Your Reference: MP 10_0140
Our Reference: RDC 10M1752 Vol 3 SYD10/00790
Contact: Dianne Rees
Telephone: 8849 2237

**SYDNEY
REGIONAL
DEVELOPMENT
ADVISORY
COMMITTEE**

**METCASH DISTRIBUTION CENTRE, BRABHAM DRIVE, BUNGARRIBEE INDUSTRIAL
ESTATE, (HUNTINGWOOD WEST)
MAJOR PROJECT – MP 10_0140**

TITLE SITE PLAN - STAGE 5

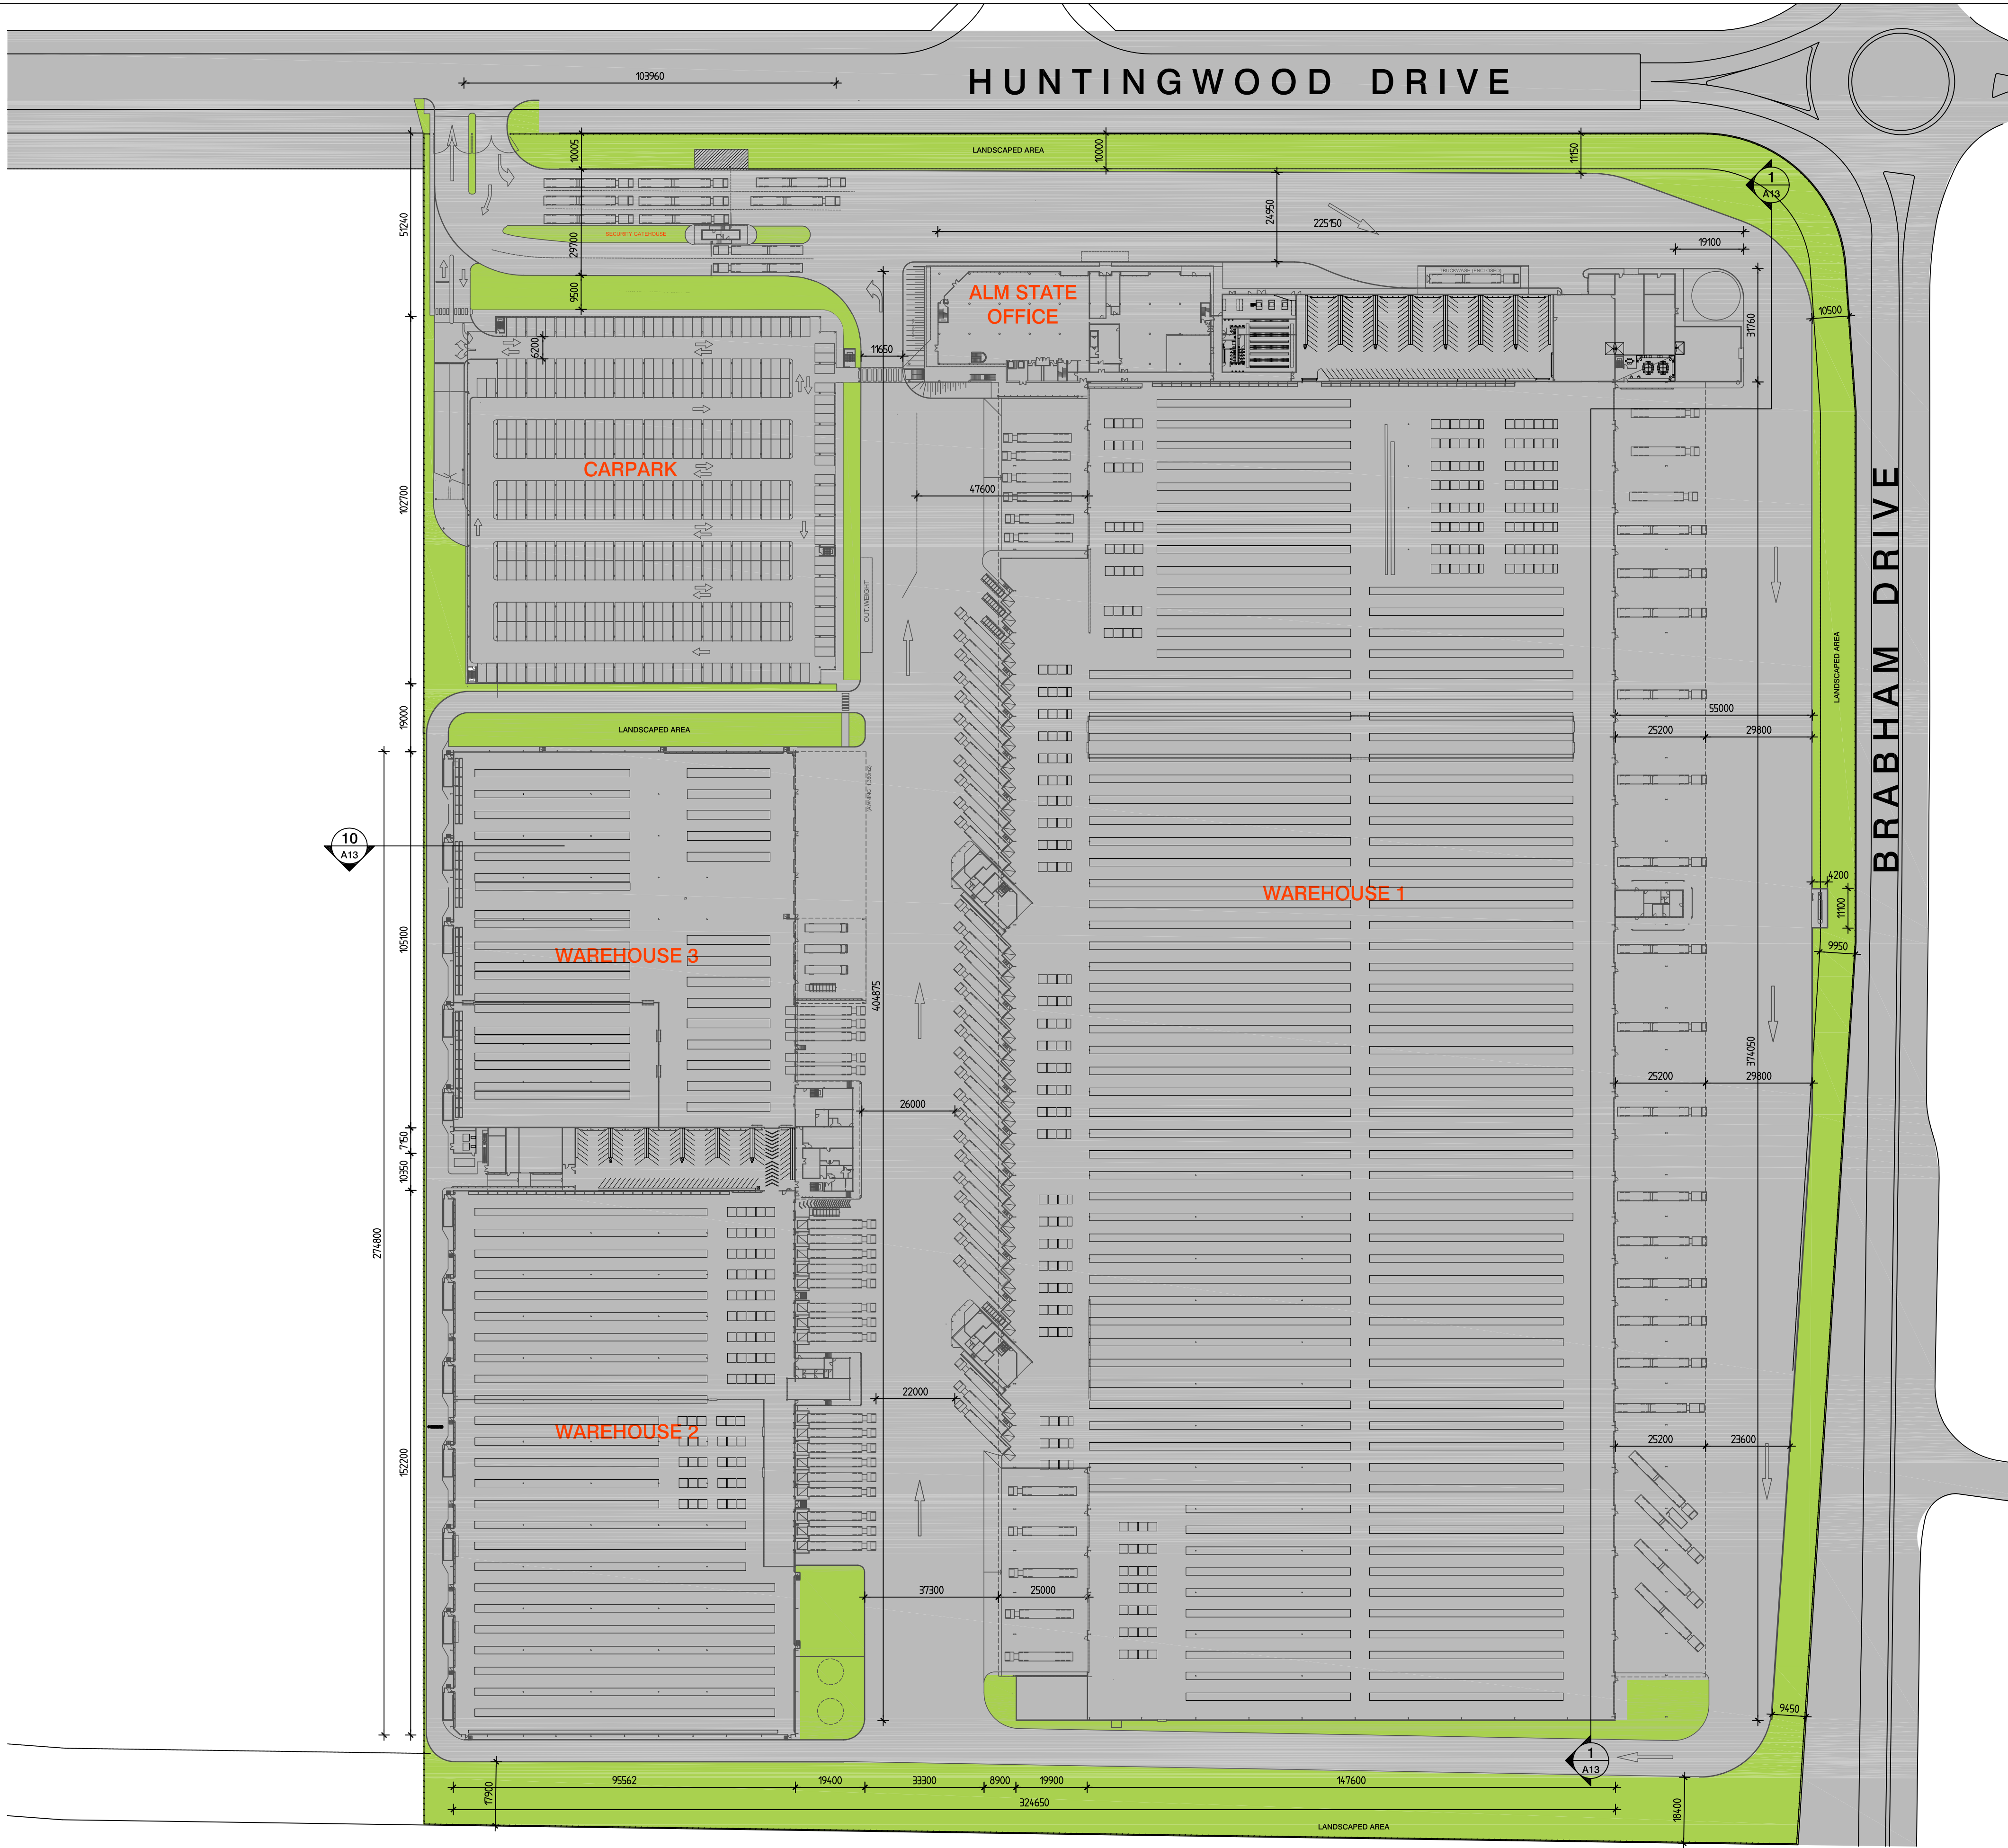
1. To eliminate vehicle conflicts between bicycles, light and heavy vehicles at the entry/exit to the site, the Department should consider requesting the applicant to redesign the entry/exit to separate heavy and light vehicles. This could be achieved by providing separate driveways for the car parking area and the heavy vehicle access.

3. The layout of the proposed car parking areas associated with the subject development (including, driveways, grades, turn paths, sight distance requirements, aisle widths, aisle lengths, and parking bay dimensions) should be in accordance with AS 2890.1- 2004 and AS 2890.2 – 2002 for heavy vehicle usage.

4. The swept path of the longest vehicle (including garbage trucks) entering and exiting the subject site, as well as manoeuvrability through the site, shall be in accordance with AUSTROADS. In this regard, a plan shall be submitted to Council for approval, which shows that the proposed development complies with this requirement.
